From: Contact Centre (CRM) <contact@ribblevalley.gov.uk>
Sent: 07 April 2024 20:36
To: Planning
Subject: Planning Application Comments - 3/2024/0187 FS-Case-603579059

Planning Application Reference No.: 3/2024/0187

Address of Development: Clayton Manor Ribchester Road Wilpshire BB1 9HU

PROPOSED CLAYTON MANOR APARTMENTS SITE LAYOUT

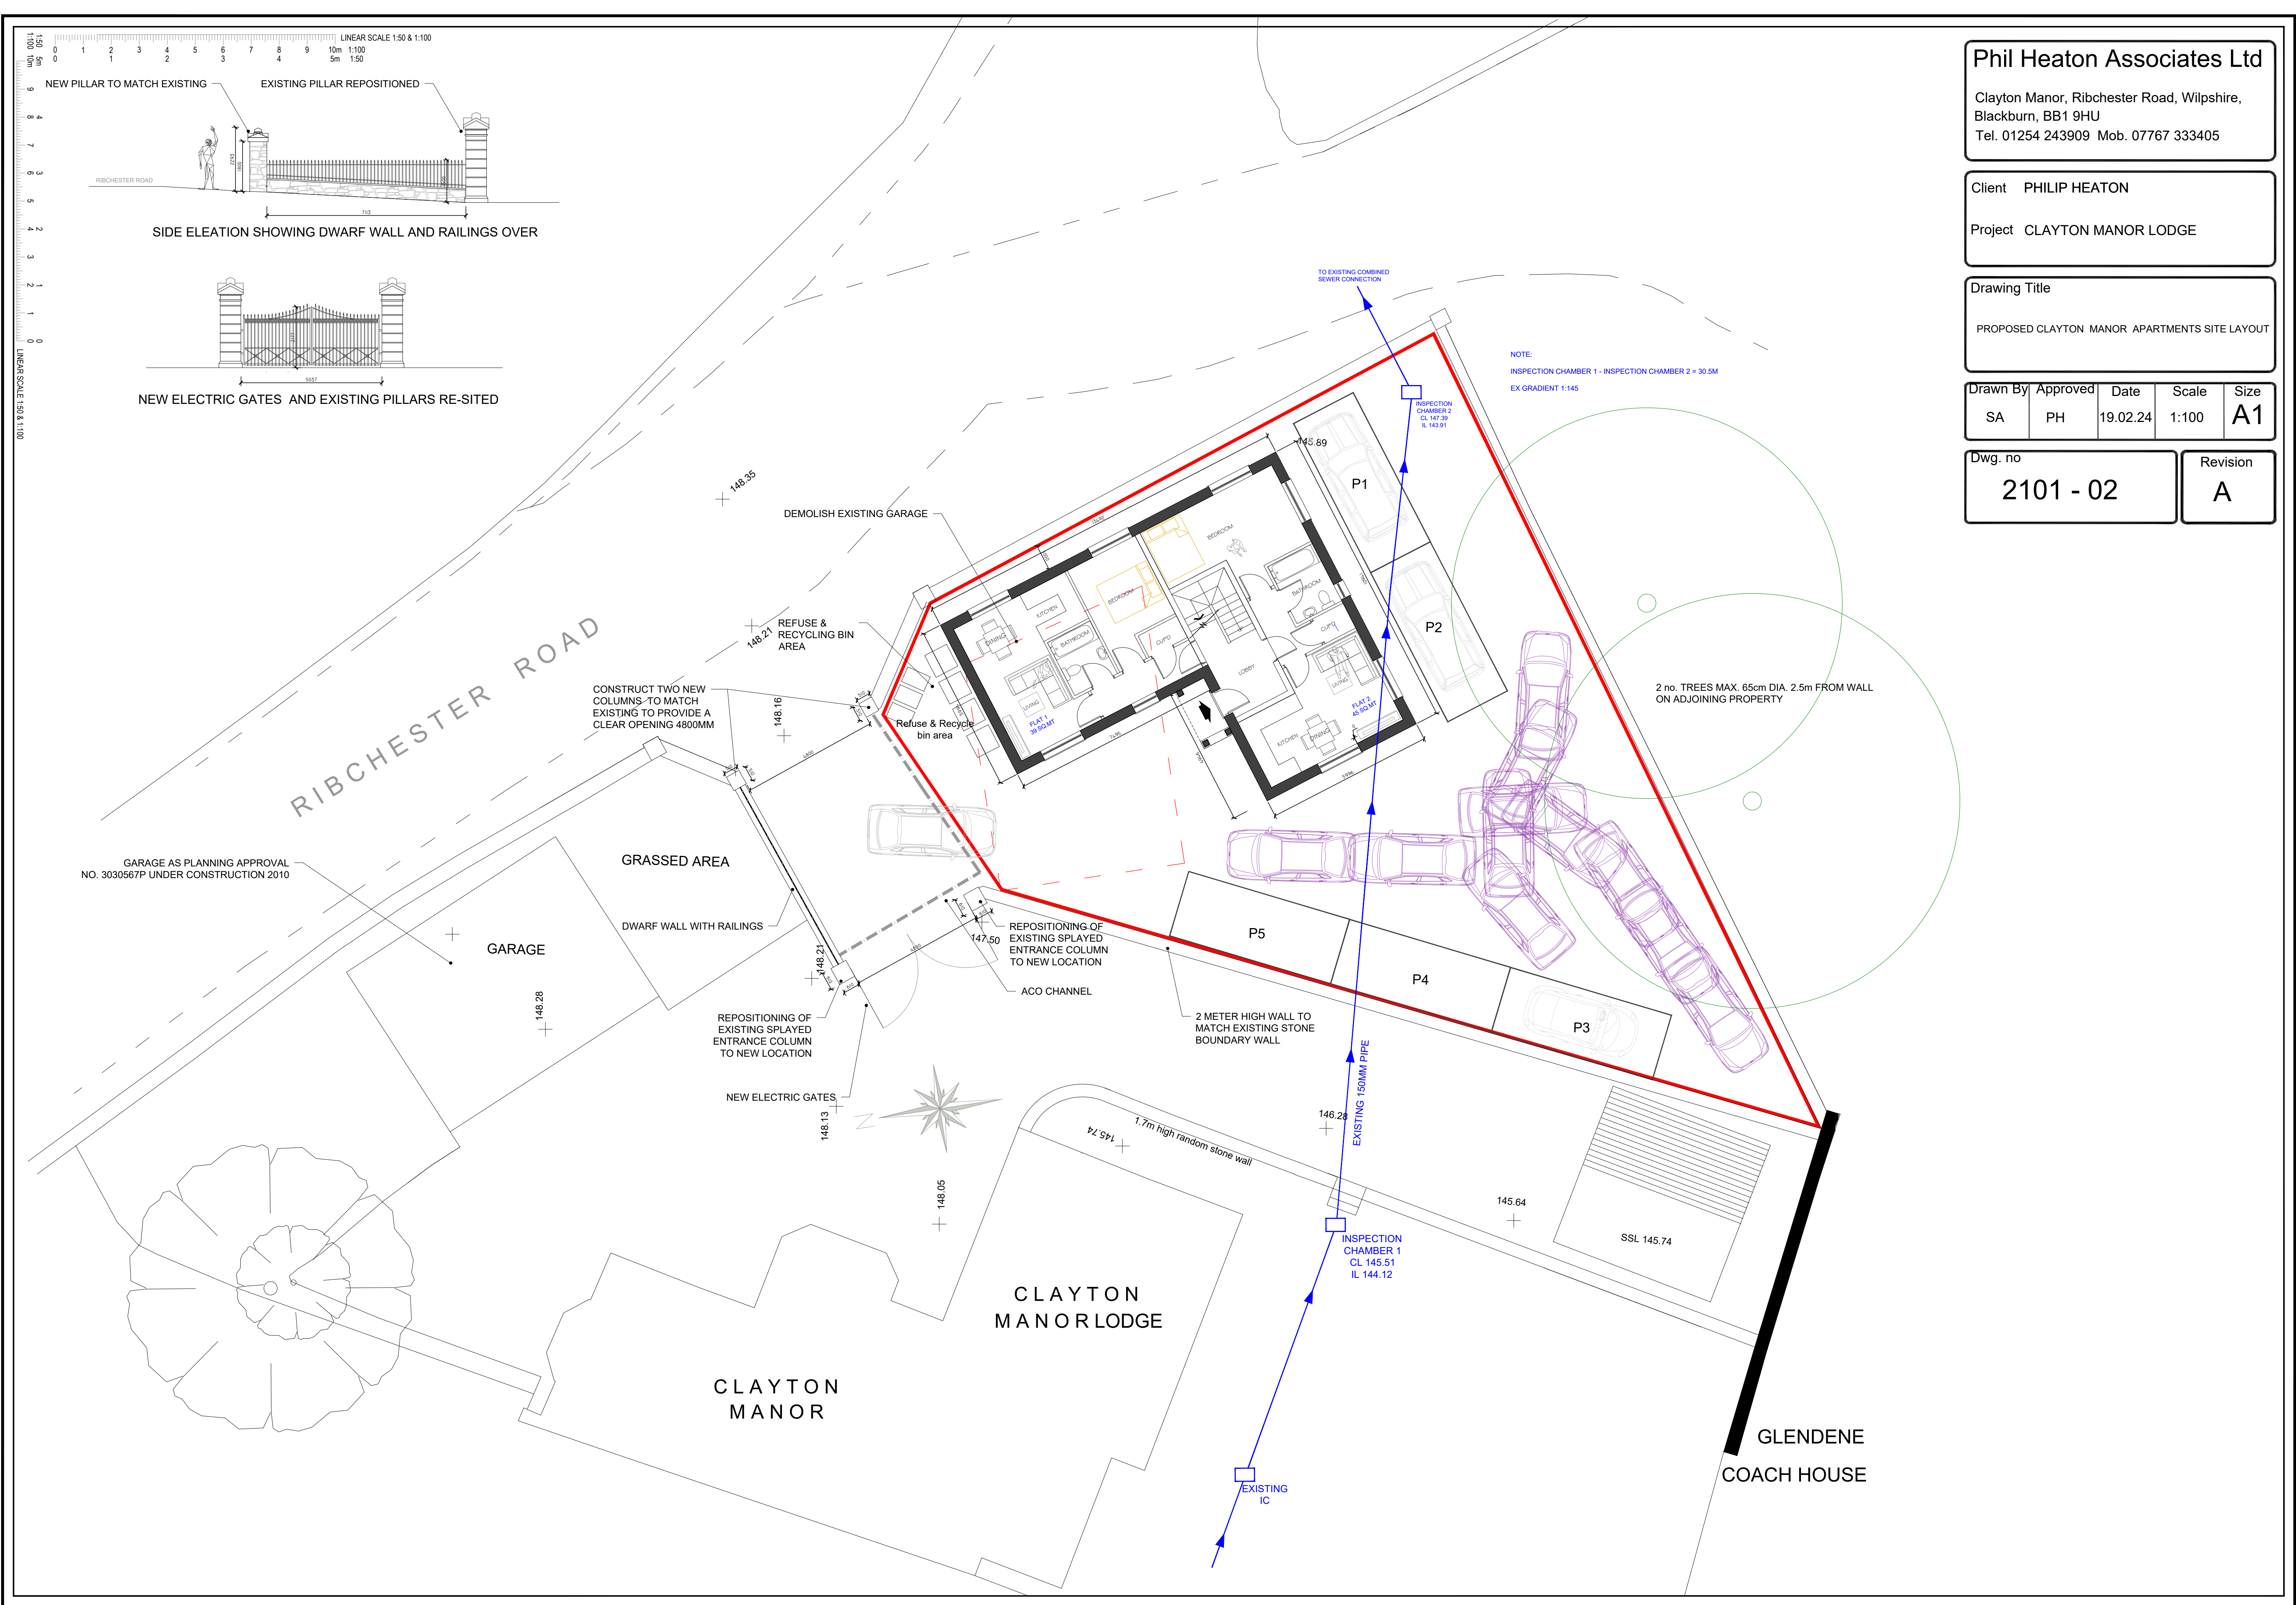
- Side elevation windows, first story, [REDACTED]

- there will be an impact on light [REDACTED] two story building will be higher than any existing height line

- I'm concerned that the addition of only 2 parking spaces for 4 new flats is insufficient.
- Many of the properties in the area have Covenants applied, restricting changes to, and use of the property and its grounds, please ensure these have been checked and followed.
